Planning Concern nE61 6LT

We have been made aware of a proposal (photo of notice attached) to build a single story extension to the rear of the property which is joined onto our house, as the building is a semi-detached property.

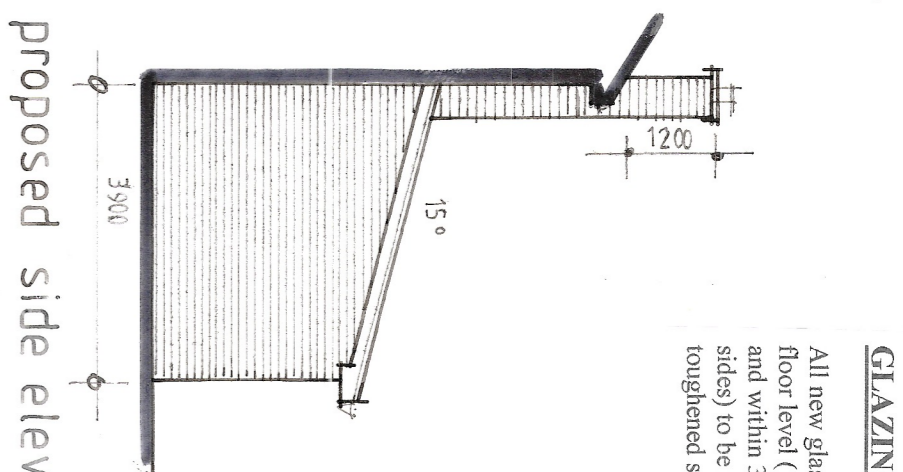
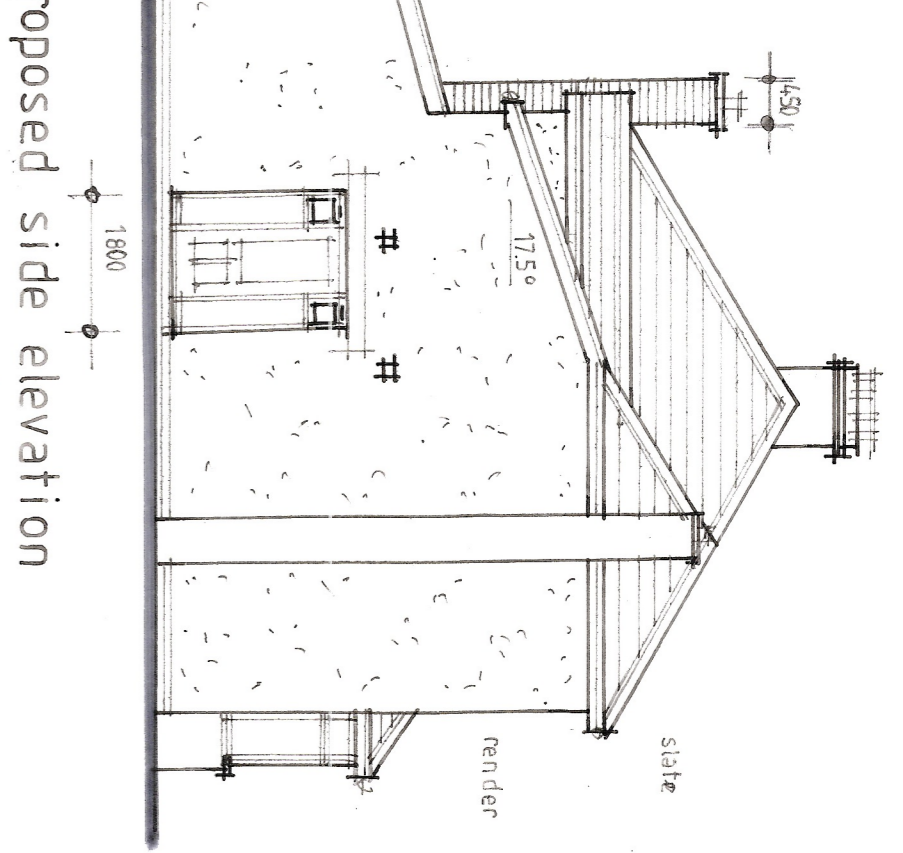
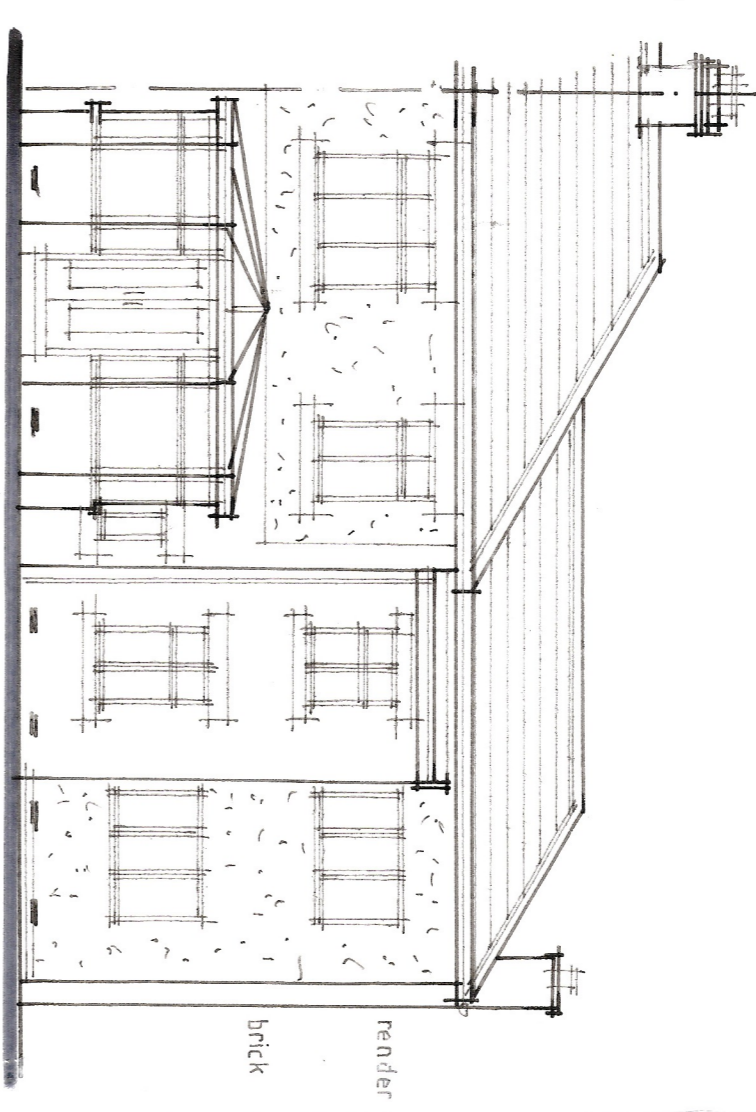
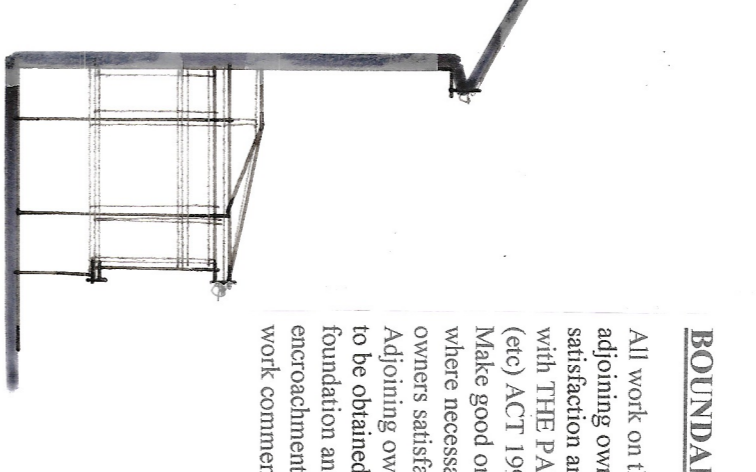
- where will the side extension wall be built. Will this be on the party line (closer than the current conservatory) ?
- How high will the side extension wall be next to my Bay window (higher than the current conservatory)?
- Will the building of the extension affect the laurel hedge we currently have between the properties for privacy?
- Will the builders need access to my property to build the extension?
